22 December 2011

Ms Holly Palmer
NSW Department of Planning and Infrastructure
23-33 Bridge Street
SYDNEY NSW 2000

**S.75W MODIFICATION TO MP10_0057 – RESPONSE TO ISSUES
132-138 KILLEATON ST, ST IVES**

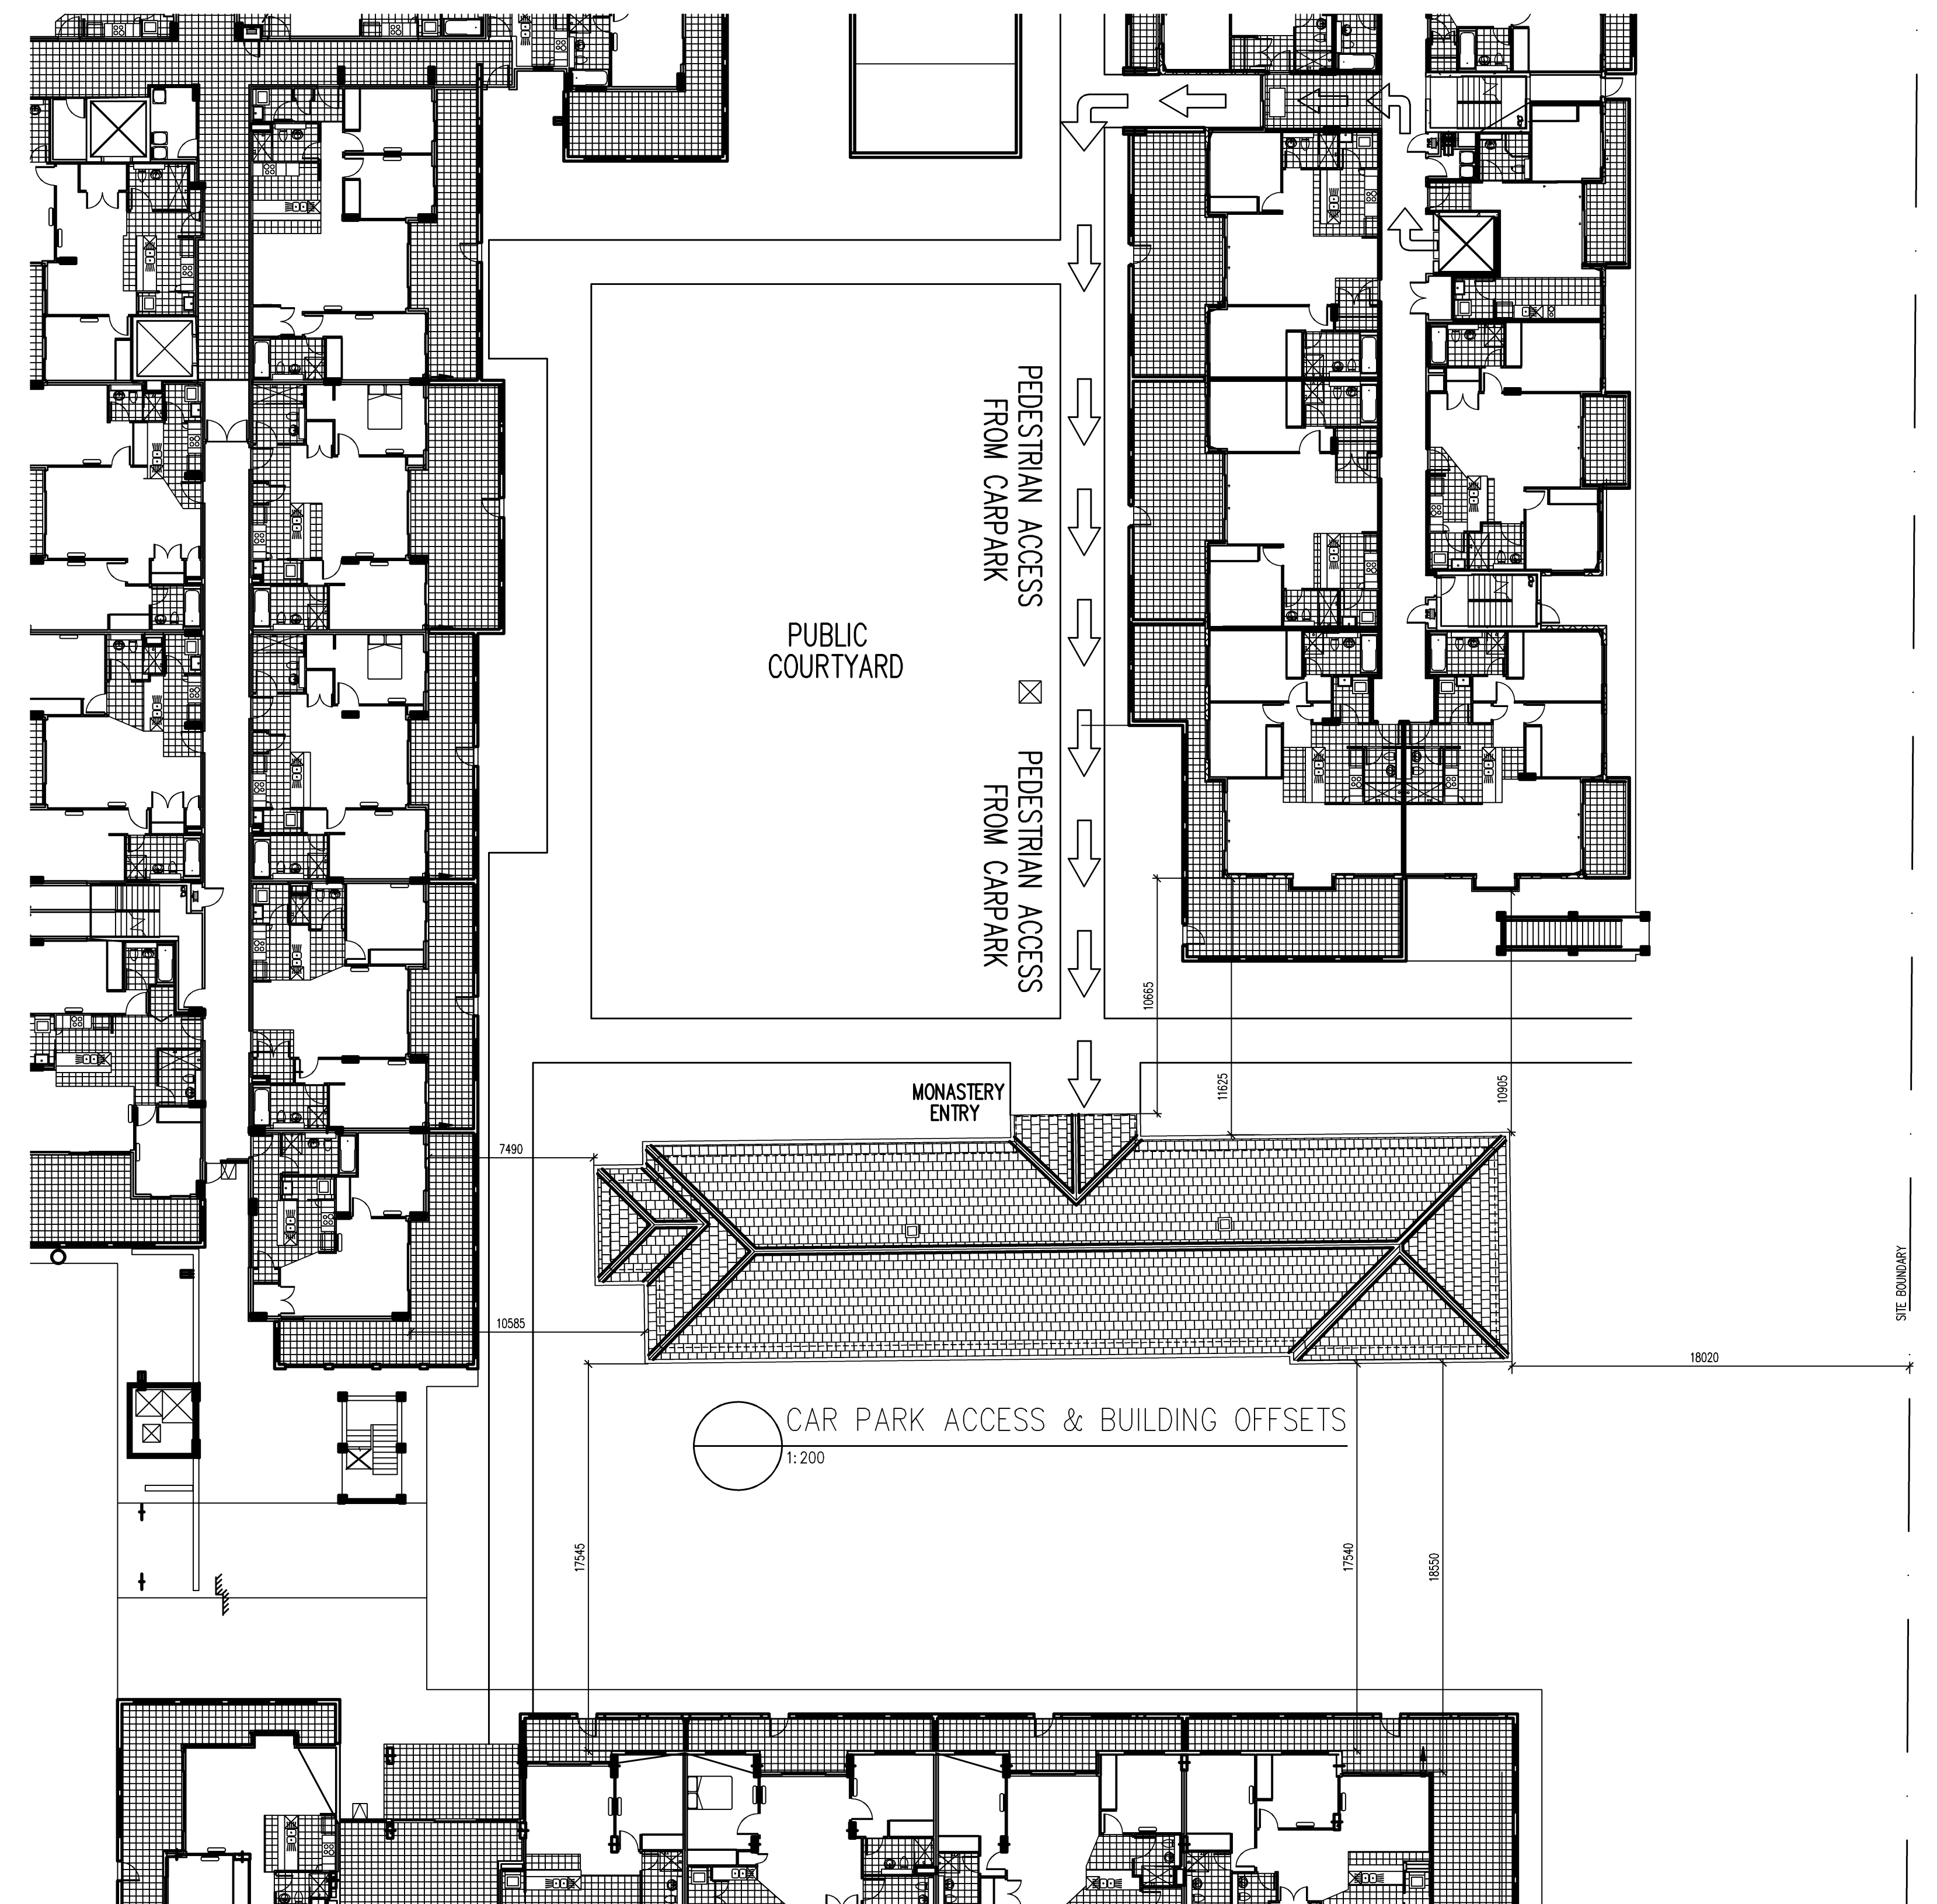
- *The actual distance of building separation to the neighbouring approved Blocks within the subject site, and the impact the additional four units will have on the privacy of the approved units within the subject site and the privacy of the neighbouring residential properties to the east.*

- *Details of how the proposed four units in the monastery building are to be accessed by residents and visitors. i.e. Is the residential access shared with the access to the community facilities?*

- Details of access to the residences of the Monastery building from the underground car park.

The architectural plans have been amended to include dimensions to the nearest buildings and the site boundary. The monastery building is 11.6 metres away from the main façade of the building to the north; 17.5 metres away from the main façade of the building to the south; 18.0 metres away from the eastern site boundary; and 7.5 to 10.5 metres away from the building to the west.

Generally, the proposal complies with respect to separation to the north, east and south. The western edge of the balcony is 7.5 metres from the windows of the adjacent building to the west. Given that the built form has been approved on the site, the issue of potential overlooking needs to be resolved. Should it be regarded as necessary, the lower half of the west-facing windows of the proposed balcony can be fitted with obscure glazing to prevent overlooking.

The ground floor level of the monastery building is to include a security entrance with intercom. Controlled access will be available to visitors. The entrance will be shared by residents who will have keypass access into the communal facilities on ground floor level.

Residents will approach their upper floor level communal lobby by climbing the stairs, which are being retained as part of the original building fabric. This ensures that the proposed units do not directly share the same lobby as that which provides access to the gym and pool.

The architectural plans have been amended to show the path of travel from the monastery entrance to the lift that provides access into the carpark basement. The proposed method of travel is the shortest and most direct possible. Access directly from the carpark into the basement is not possible because the basements are not being built beneath the monastery building.
